**RE: PROPOSED DEVELOPMENT AT TERRANORA AREA E, ALTITUDE ASPIRE,
PROJECT APPLICATION MP09_0166**

I refer to the Project Application, Environmental Assessment, and accompanying information provided for the proposed 321 lot residential subdivision at Fraser Drive, Terranora, received by the Department of Environment, Climate Change and Water (DECCW) on 31 January 2011.

ATTACHMENT 2 – DECCW'S ASSESSMENT OF THE PROPOSAL AND JUSTIFICATION FOR RECOMMENDED CONDITIONS OF APPROVAL

METRICON (QLD) PTY LTD
ALTITUDE 1 - FRASER DRY, TERRANORA
CENTRAL OPEN DRAIN
LONG. SECTION

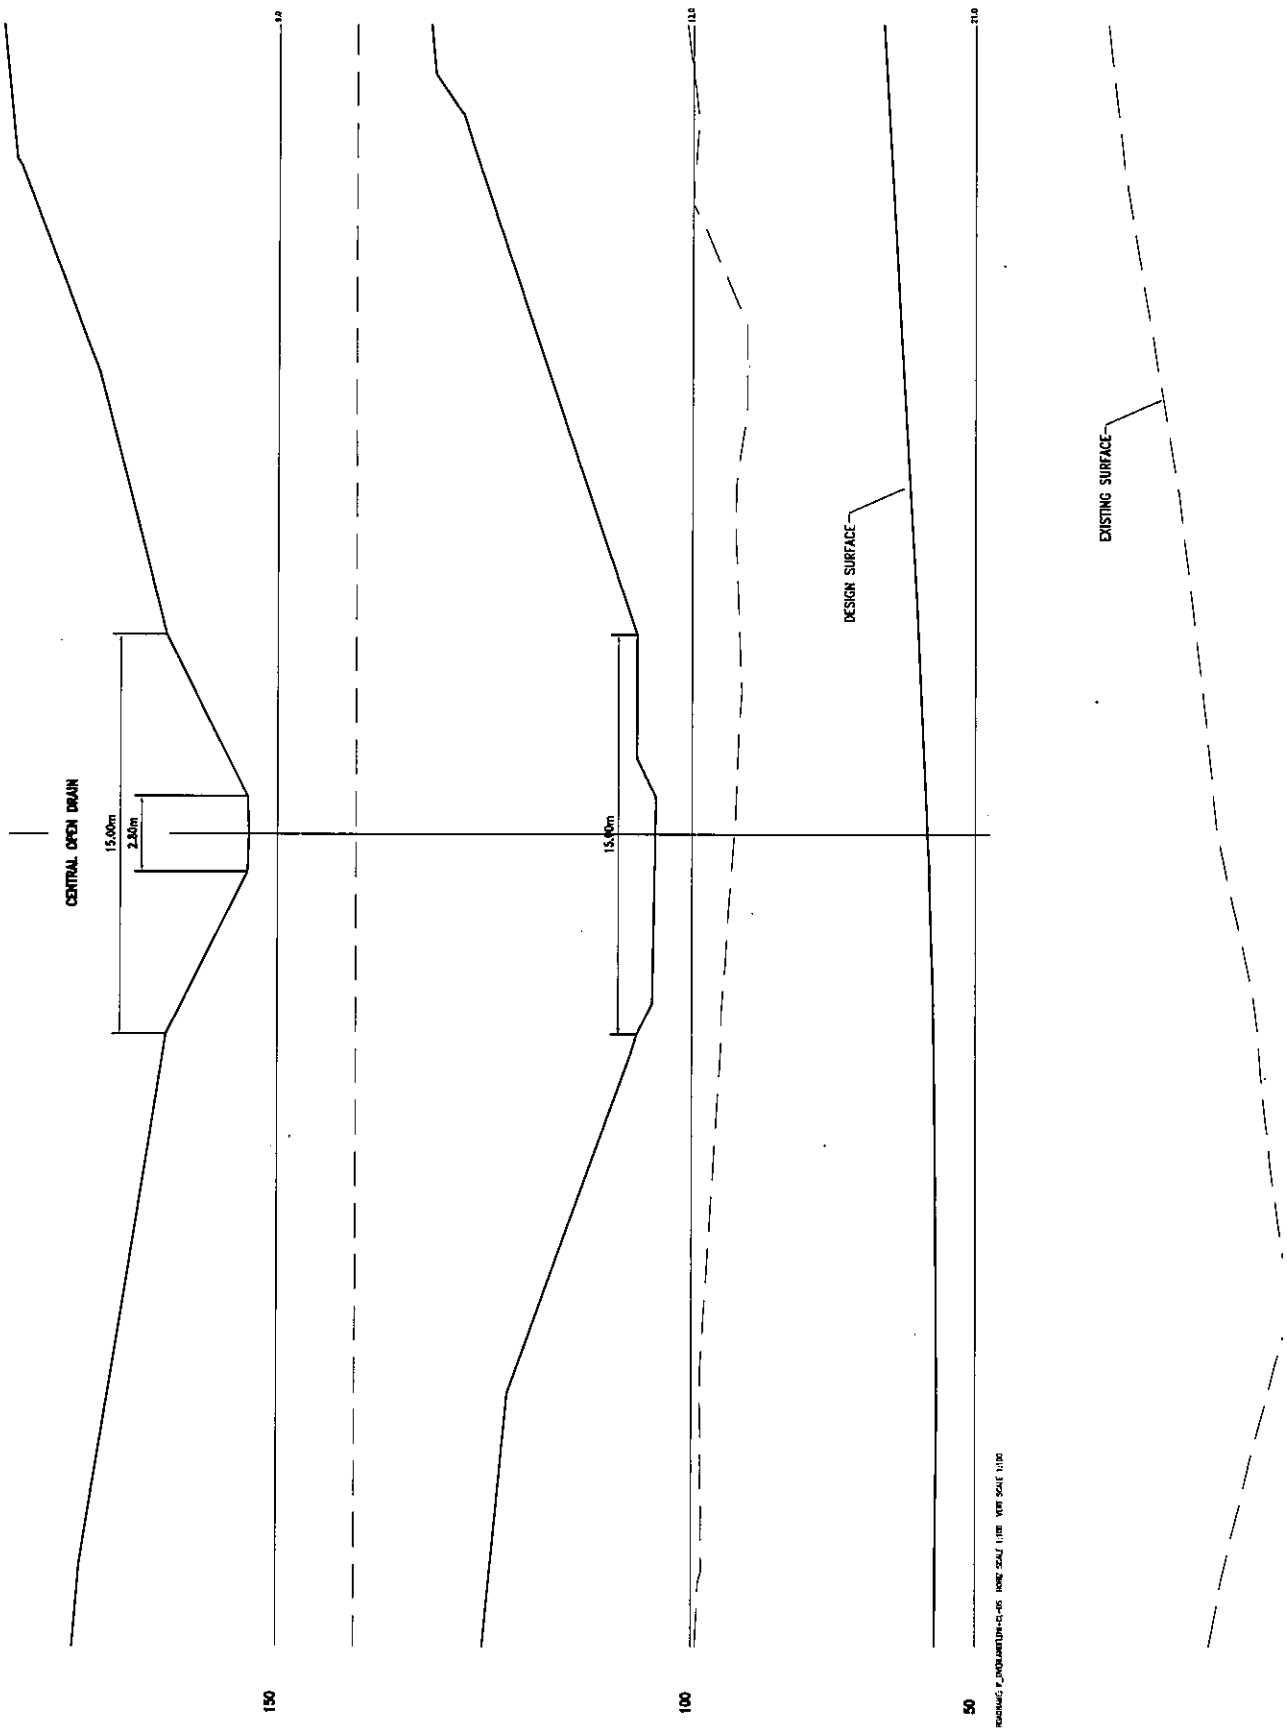
1. The allotment design is to be modified to avoid impacting on the identified EECs within the site by the removal or relocation of the 20 allotments adjacent to the central drainage line.
2. The allotment design is to be modified to allow for access points other than the currently proposed Broadwater Parkway route, to avoid impacts on the Freshwater EEC and the SEPP 14 Wetland.

- DECCW does not support the inclusion of WSUD measures within the mapped area of the Freshwater EEC given its status and value. It is also inconsistent with DECCW stormwater guidelines. An allotment modification around the central drainage line would alleviate the impact on the Freshwater and Lowland Rainforest EECs, allow for better drainage, provide more recreational access and avoid rubbish dumping over fences.

BROADWATER PARKWAY
LAYOUT

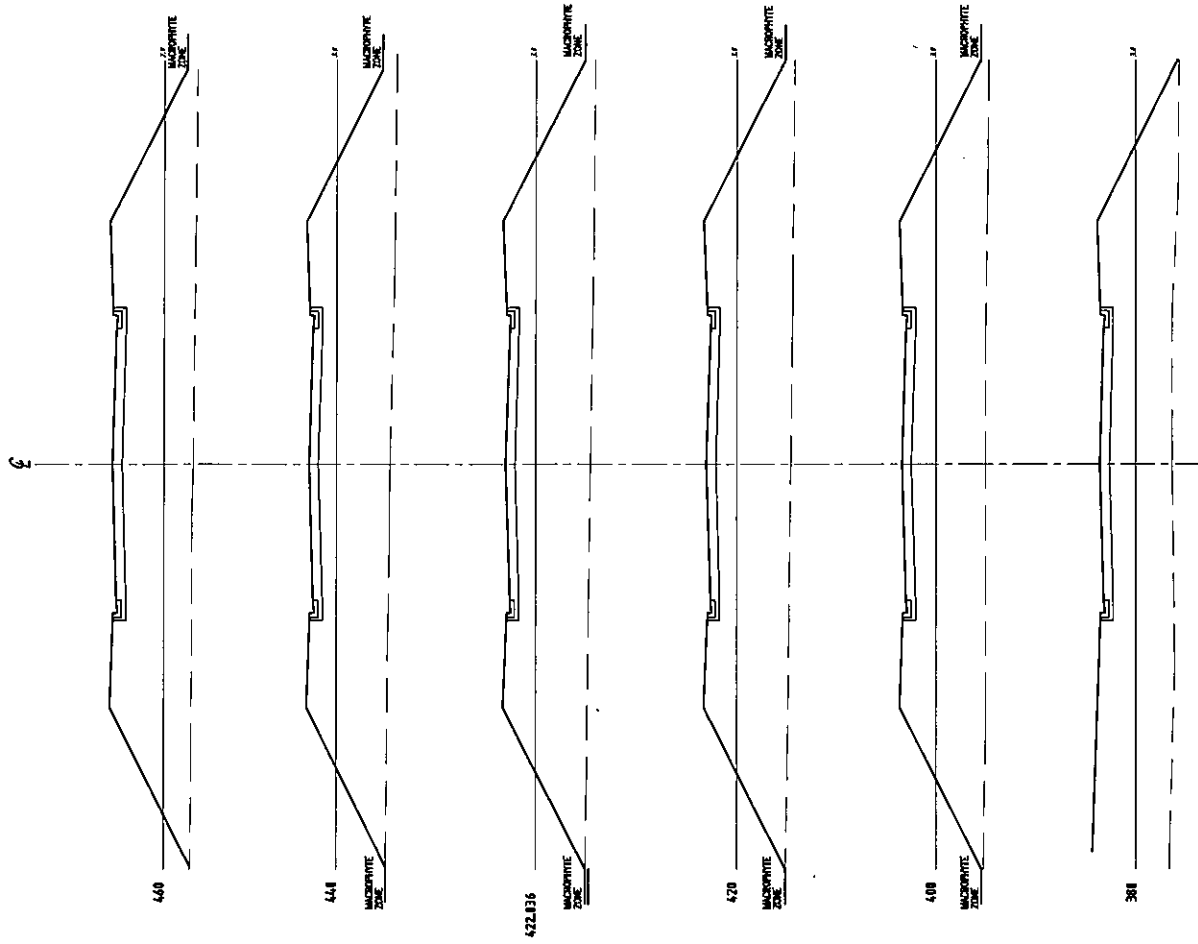
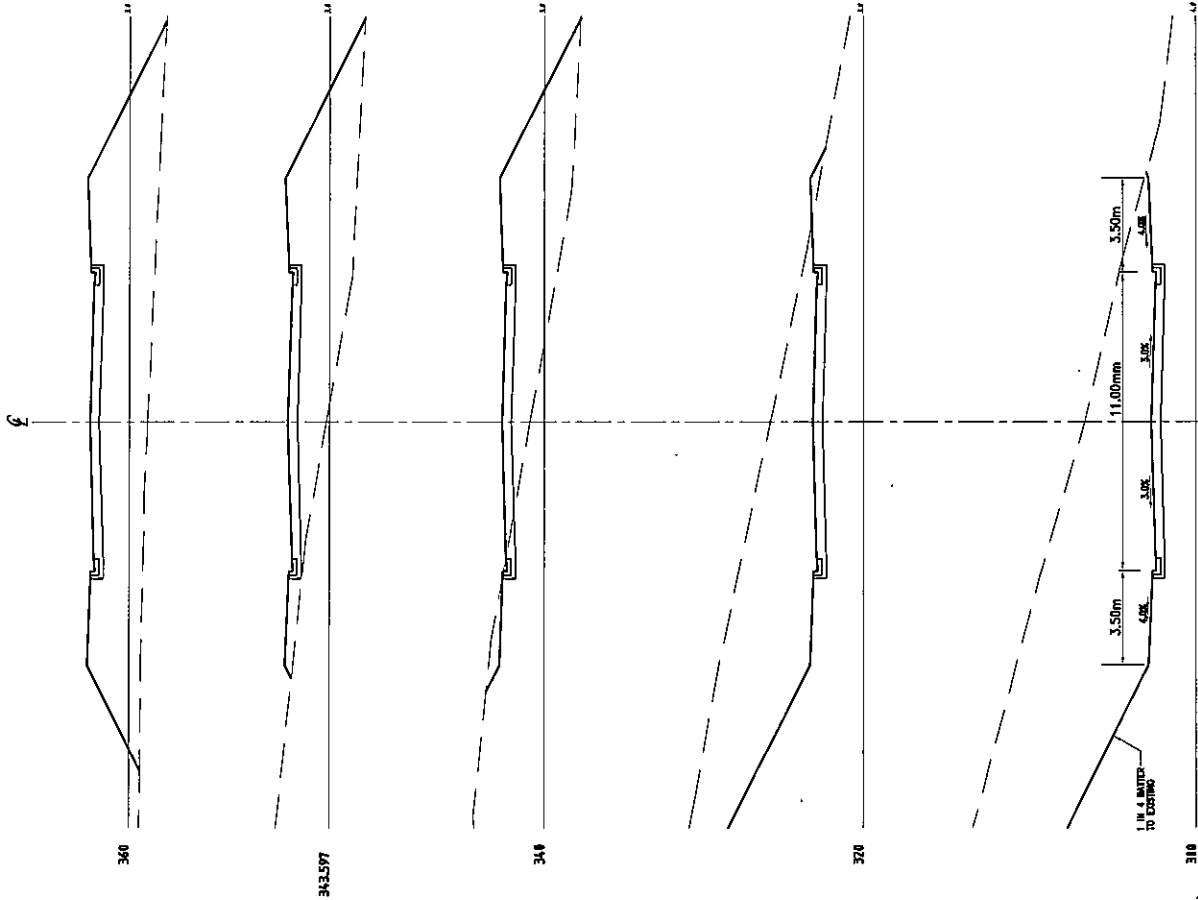
1. The route and design of the Broadwater Parkway is to be modified to avoid impacting on the identified EECs within the proposal and beyond.

- It is understood that the proposed Broadwater Parkway is to be created solely for the purpose of providing access to the development. However, DECCW believes the impacts for nature conservation within the development site and more widely in the region with the extension of this road are potentially significant. DECCW recommends that other options for access should be explored to avoid the impact on the identified Regional Corridor.
